# The Sizewell C Project

SZC Co.'s Response to the Secretary of State's Request for Further Information dated 31 March 2022: Appendix 7 - Additional technical information to support Question 8.4 in relation to Environment Agency comments on assessment of sea bass

Revision: 1.0

April 2022

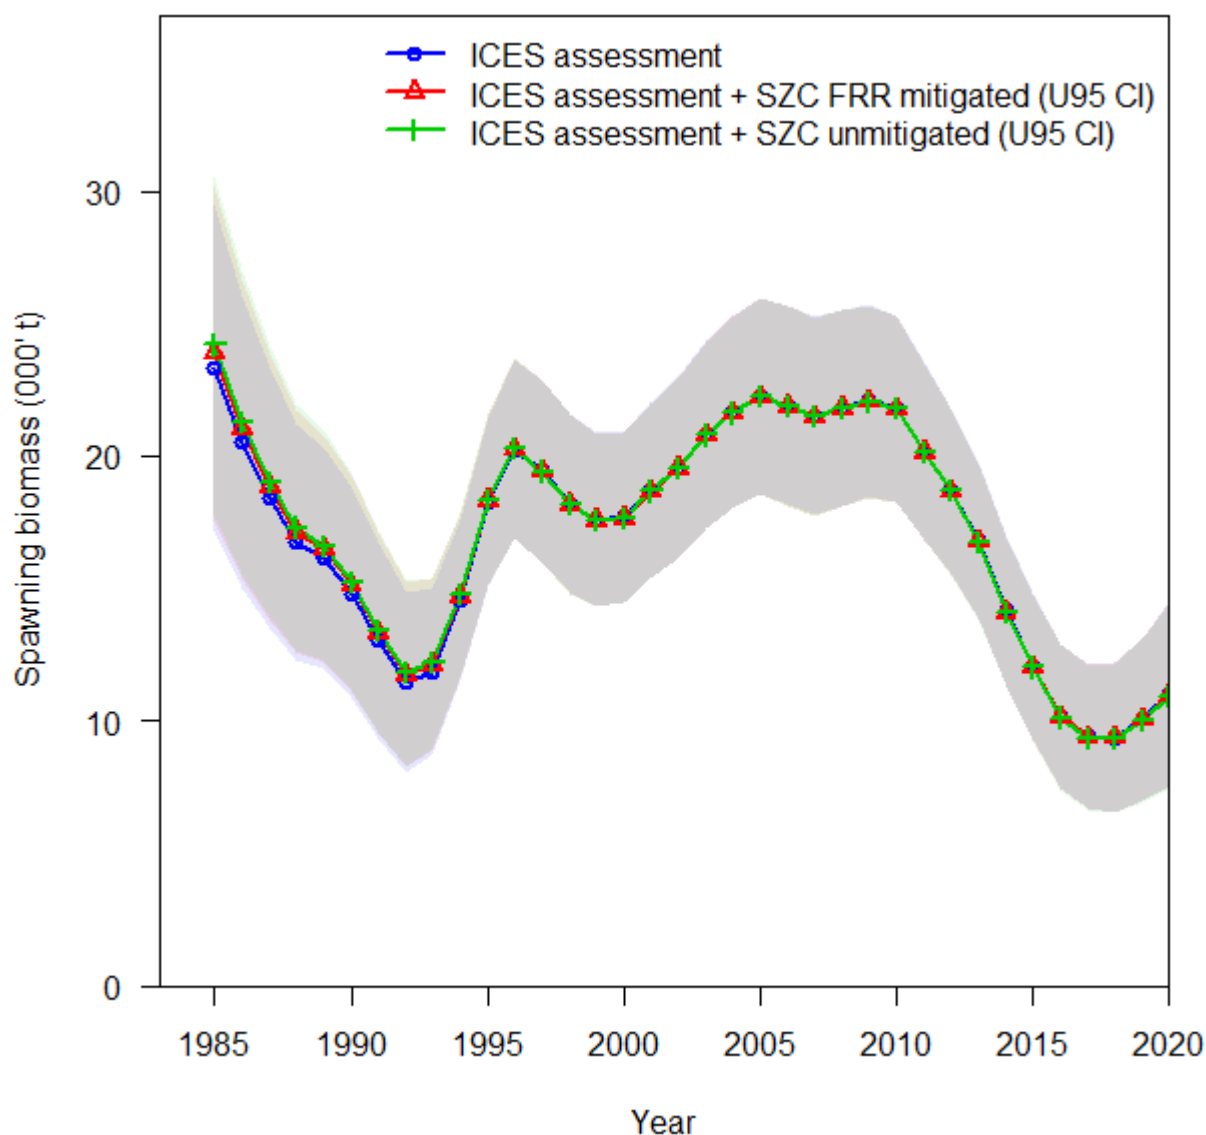
*“Issue: Years of stock assessment versus health of seabass fishery.*

*Comment: The stock assessment has included years 1985-2020 however it has not taken into account the most recent stock assessment and fisheries advice which shows that the stock is currently below safe limits.*

*Suggested solution: The analysis needs to include the current state in the assessment and the assumption of a 50 year lifetime on the plant acting on a stock that is currently at the lowest safe limits”.*

- 1.2.2 The sea bass stock has fluctuated over time between 1985 and 2020 (Figure 3). A decline from 2010 onwards brought about a series of management measures, including the prohibition of pelagic trawls and gillnets during the first six months of the year, bag limits for recreational fishing, and an increase in the minimum conservation reference size (MCRS) to 42 cm. The stock SSB fell to its lowest point below  $B_{lim}$  (the biomass limit reference point, below which there is a high risk that recruitment will be impaired) in 2018. Management measures implemented since 2015 have resulted in the SSB showing signs of recovery, increasing above  $B_{lim}$ , although SSB remains below pre-2010 levels. As a consequence, the SSB advice for total removals increased in 2022 to 2,216 tonnes (ICES, 2021<sup>4</sup>).

- 1.2.3 Consequently, accounting for the slight improvement in sea bass stock status since 2020 would not change the conclusions. The assessment provided is sufficient to demonstrate that effects of impingement are insignificant in relation to the effects of fishing and recruitment that are the main drivers of trends in spawning population size.

1.2.7 Crucially, when the additional mortality of Sizewell C was included in the model run, even under the most extreme scenario the increase in SSB in 2019 and 2020 following the lowest levels in 2018 was unhindered (Figure ). This period represents the most sensitive period of recovery from levels below  $B_{lim}$ .

1.2.8 Whilst the stock assessment does not provide a forward projection of 50 years into the future from 2020, there is an analogous period in the early 1990s when SSB fell from over 20,000 tonnes to 11,500 tonnes in 1992. The population recovered in the mid-1990s and achieved a period of high biomass between the mid-1990s and 2010 driven by above average recruitment. Again, the addition of extreme impingement losses did not influence the recovery of the stock during this potentially sensitive period (Figure 3). These results provide a convincing demonstration that, once SZC is operating, the size of the adult sea bass population will increase and decrease at the same times, and at almost identical rates, to those expected without impingement. This is because the environment and fishing mortality are the overriding drivers of sea bass abundance.

Figure 3. ICES stock area for sea bass showing spawning and nursery areas relative to Sizewell C (SZC) and Hinkley Point C (HPC).

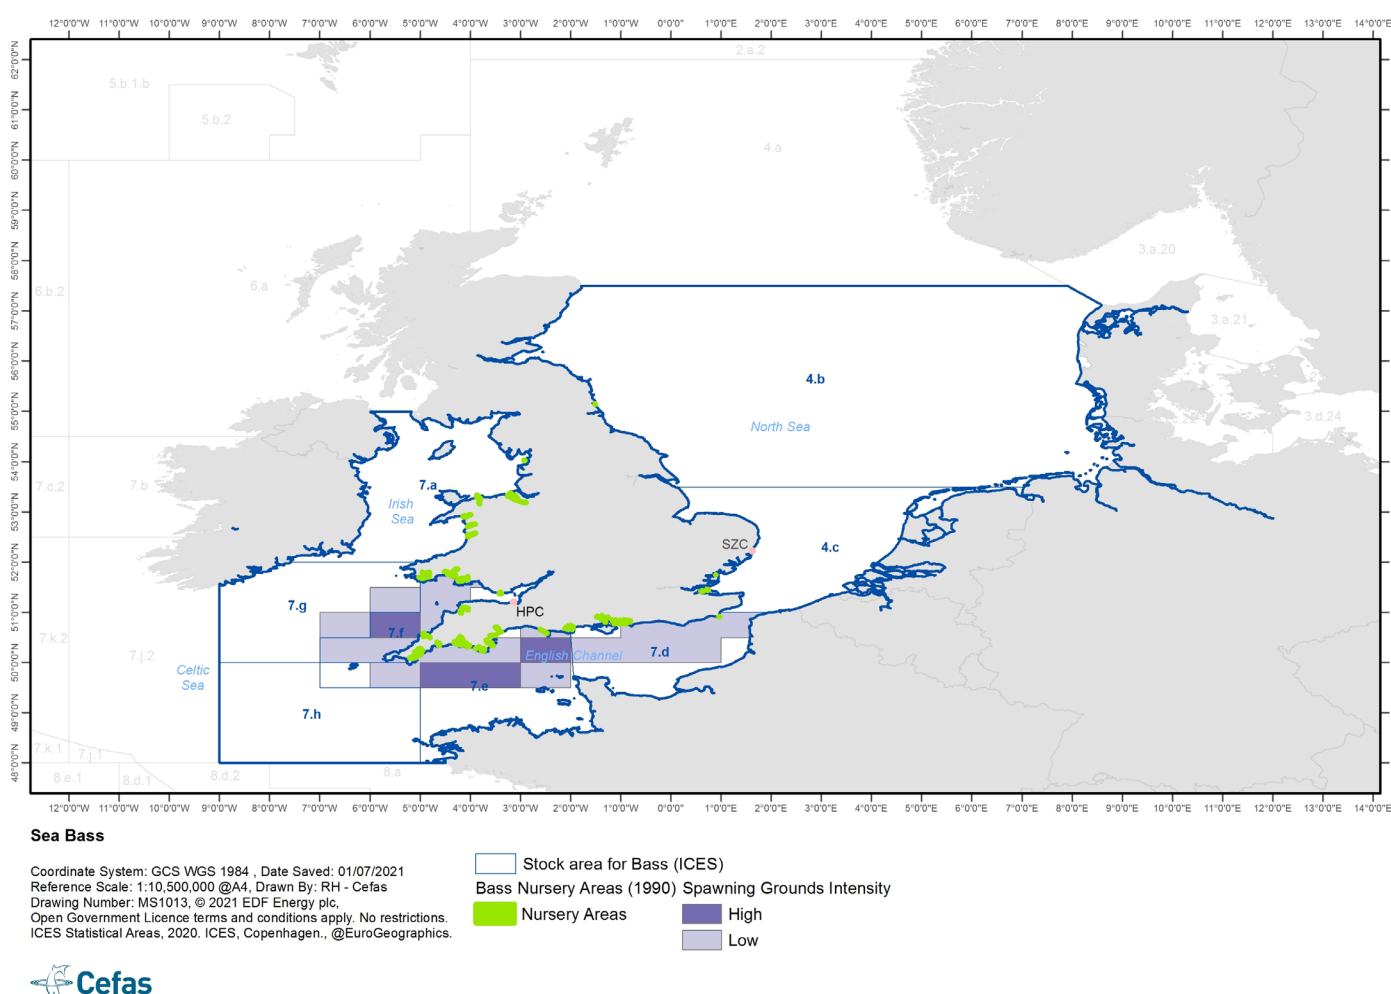
*“Issue: The stock assessment method does not address the EA concerns over the area of assessment. Using ICES stock assessment areas assumes an area for European seabass of 608,983 km<sup>2</sup>.*

*Comment: Recent papers, including Stamp et al. (2021), identified juvenile and sub-adult movements to inform recovery strategies for high value fishery – European bass (*Dicentrarchus labrax*) which shows high site fidelity of juvenile and sub-adult seabass.*

*Suggested solution: Need to provide an assessment at an appropriate local scale for European seabass that recognises the latest research into site fidelity and seabass movement and the likelihood of local populations that could be impacted by SZC”.*

*“Evidence provided to HPC inquiry showed modelled seabass recruitment from different parts of the ICES area. Contribution of major western spawning grounds to North Sea was relatively small, which supports ‘splitting’ the stock in terms of assessing impacts. See evidence provided in Figure 6 in Beraud et. al., (2018)... Additional information on seabass population is presented but this doesn’t include all the information presented at HPC inquiry (larval drift modelling, which showed little contribution of western areas to North Sea seabass doesn’t seem to be referenced). Selected tracks<sup>2</sup> show two seabass tagged off SZC going to English Channel, but also shows two tagged in channel/Irish Sea never going to North Sea.”*

### 1.1.1 SZC Co. does not agree with the Environment Agency’s position in relation to the scale of assessment for effects of Sizewell C on the population of sea bass. The population comparator applied by SZC Co. is consistent with the most robust internationally accepted stock unit for sea bass. In the case of commercially targeted fish species such as sea bass, the stock units applied by SZC Co., as set out below, have been supported by the MMO.

### 1.1.2 To determine the population level effects of impingement on sea bass, SZC Co. has incorporated predicted impingement impacts with the full analytical International Council for Exploration of the Sea (ICES) stock assessment for the ICES stock area for ‘Northern’ sea bass. Sea bass is a migratory species, and the stock area covers the central & southern North Sea, Irish Sea, English Channel, Bristol Channel & Celtic Sea of ICES Divisions 4.b-c, 7.a, & 7.d-h (Figure 1). ICES role as the main international advisor on the status of fish populations in the North Atlantic, along with the safeguards and transparency of its advisory process, endorse that its assessments provide the best available and internationally reviewed evidence on the status of assessed stocks, including sea bass. To generate its advice, ICES assesses all the available evidence of the species of concern throughout its full life cycle including spawning migrations, larval dispersal, and patterns of recruitment.

1.1.9 **Conclusion:** When determining the appropriate scale of assessment, the full life history of species must be considered. SZC Co. contends that the ICES stock areas are the most robust application of the evidence for determining population units for commercially harvested data-rich species, such as sea bass.
